APPLICATION NO. 03-00647	PROJECT NO. 1002603
PROJECT NAME EAGLE ROCK EST., UNIT 1	
EPC APPLICATION NO.	
APPLICANT / AGENT MARK GOODWIN & ASSOC	PHONE NO. 828-2200
ZONE ATLAS PAGE C-19	
(SDP for SUB), (SDP for BP), (FINAL PLATS), (MASTER DEV PLAN), (IR), (AA)	
ONE STOP COMMENT FORM LOG

CITY OF ALBUQUERQUE
PLANNING DEPARTMENT
DEVELOPMENT REVIEW BOARD

MARK GOODWIN & ASSCO agent(s) for SUNSET WEST request(s) the above action(s) for all or a portion of Tract(s) A & B < known as Public Drainage Easements >, **EAGLE ROCK ESTATES, UNIT I, POND RECLAMATION**, zoned R-D/7DUac, located on MODESTO AVE NE, between LOUISIANA BLVD NE and VISTAS DR NE containing approximately 8 acre(s). [REF: DRB-97-375] [Deferred from 5/21/03] (C-19)

PROPERTY CORNERS

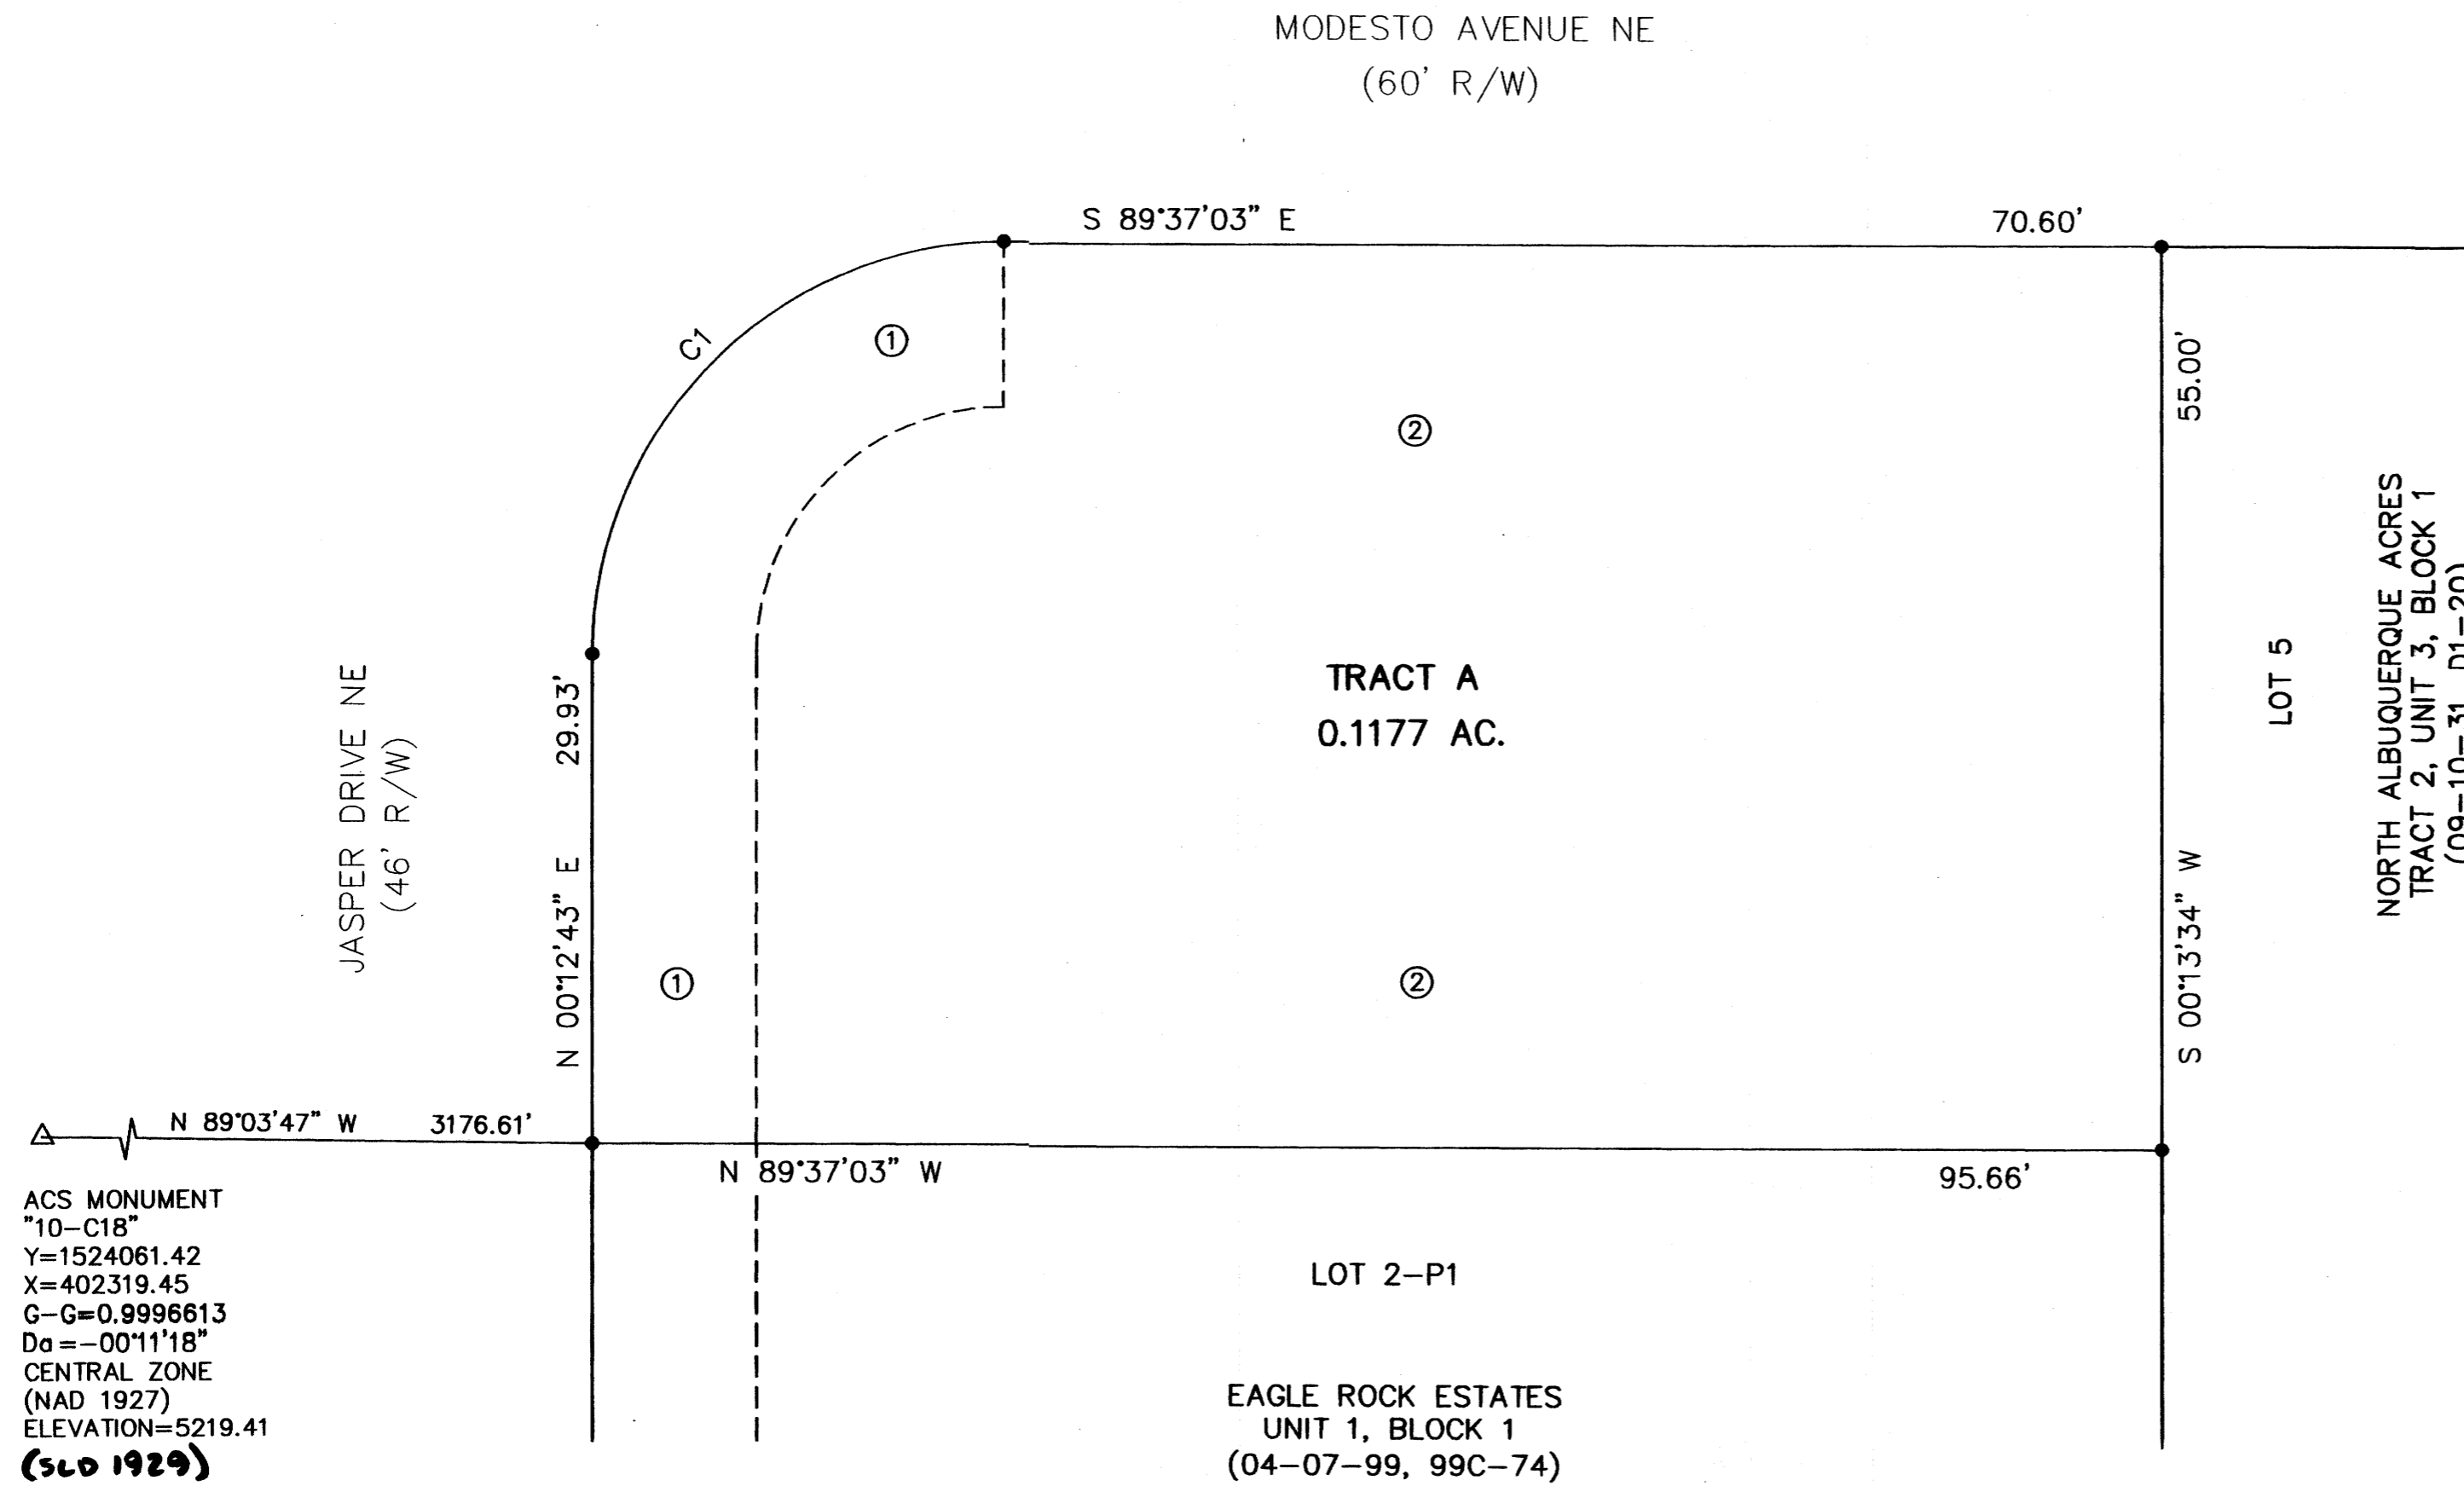
Amy Driscoll is going to submit a correction plat for this subdivision giving the pond a legal description on the plat. You & I will need to sign (or initial) it. Then they will re-submit the new plat. We deferred the case for ~~one~~ ² weeks.

The Hydrology Section has no objection to the vacation request.
 Need correction plat to define tracts being subdivided.
 An approved drainage plan dated 4-22-03 is on file for Preliminary Plat approval.
 Engineer's Certification of the grading plan is required for Final Plat sign-off.

No objection to Vacation requests. Prior to approval of Final Plat, a Correction Plat must be done on the original plat to give temporary public drainage easements a tract designation.

EAGLE ROCK ESTATES - UNIT 1 POND RECLAMATION GRADING AND DRAINAGE PLAN

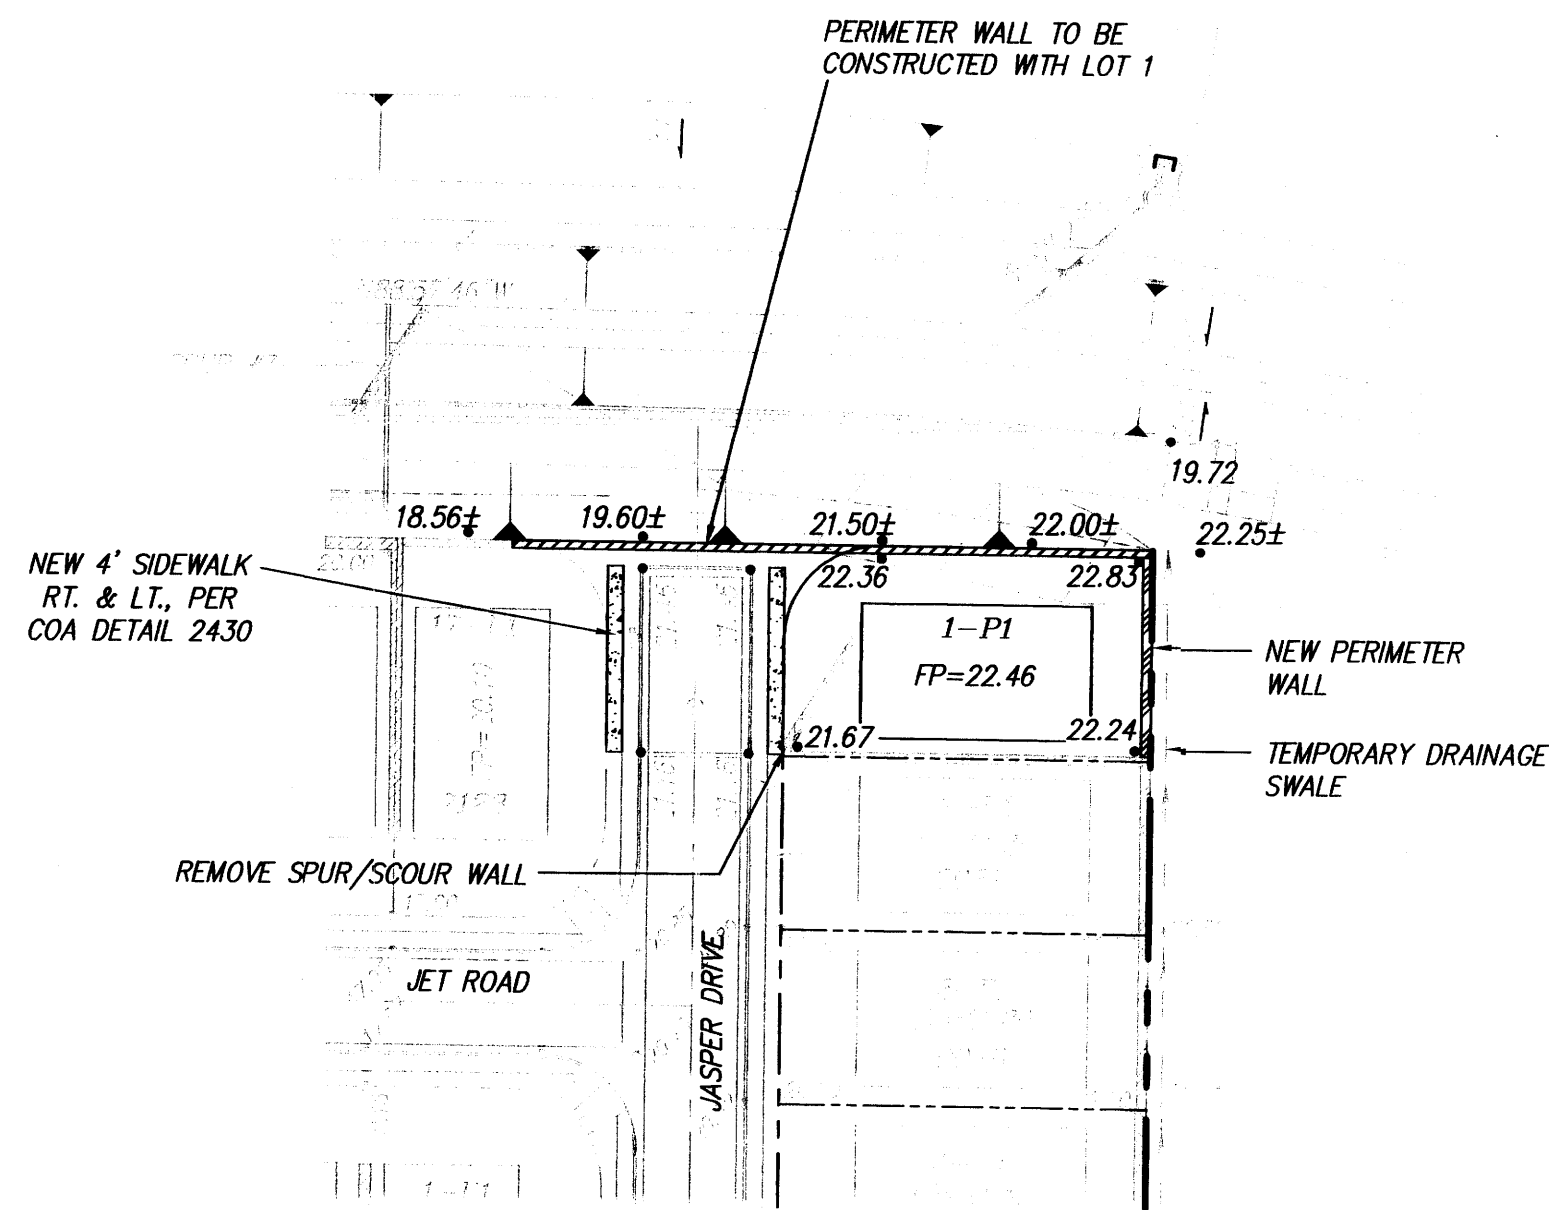
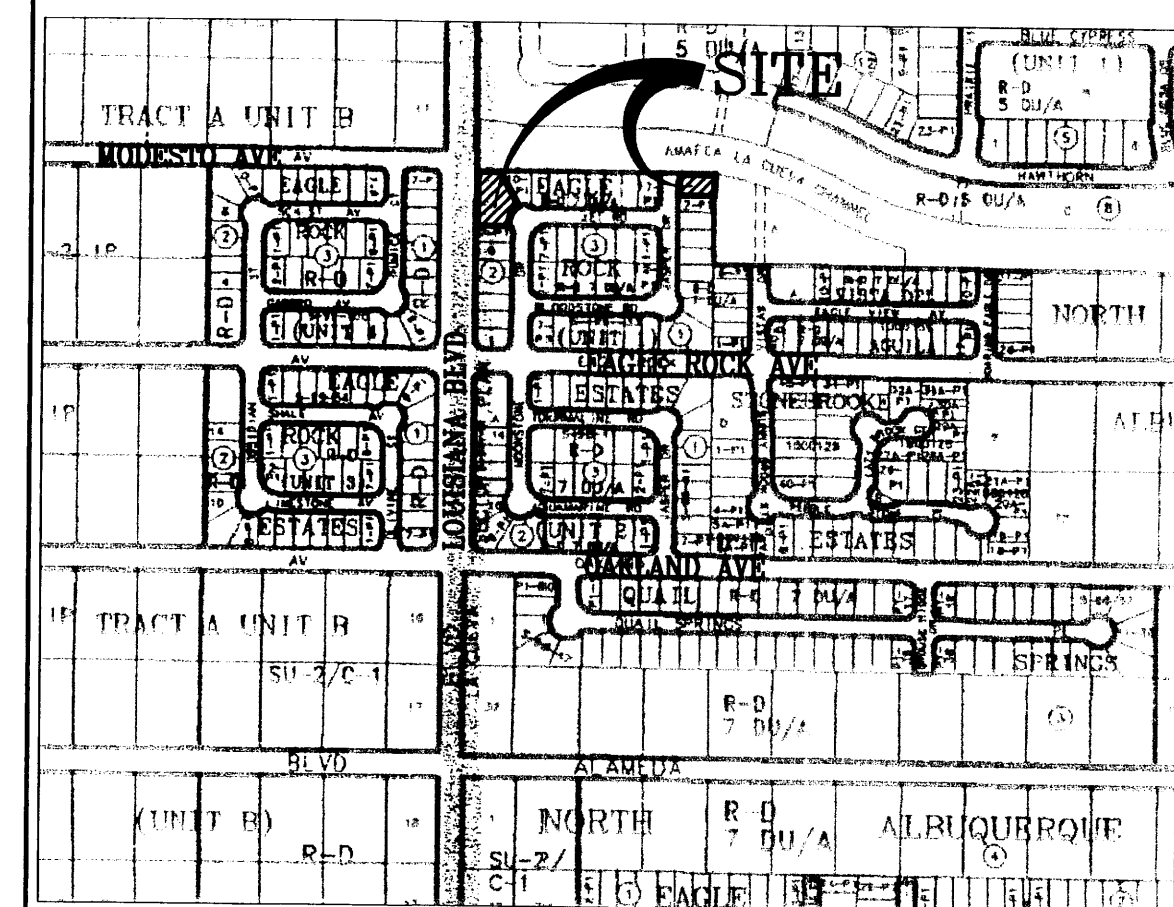
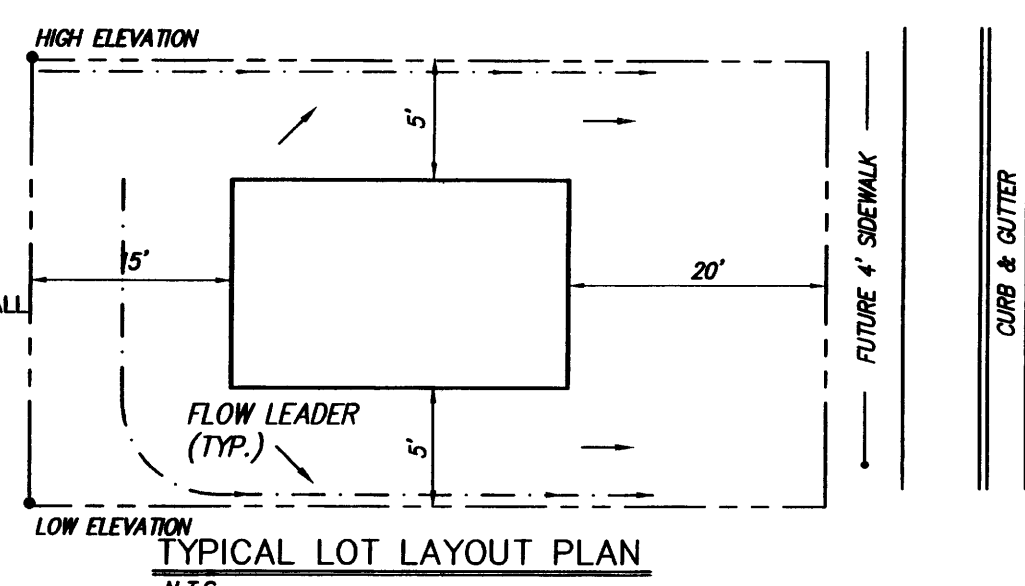
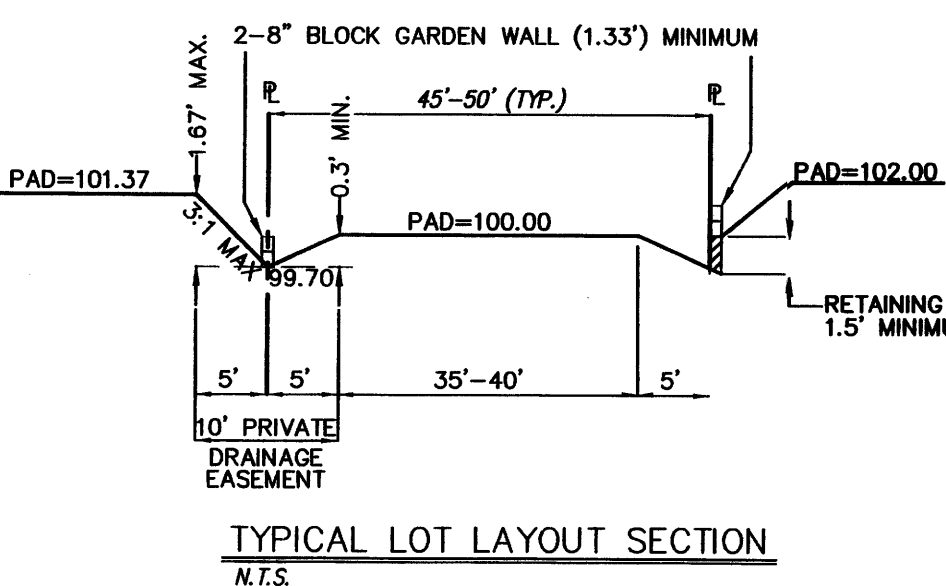
No objection to vacation request. Approved grading and drainage plan required prior to Preliminary Plat approval. Engineer certification of grading plan required prior to City Engineer signoff of Final Plat.
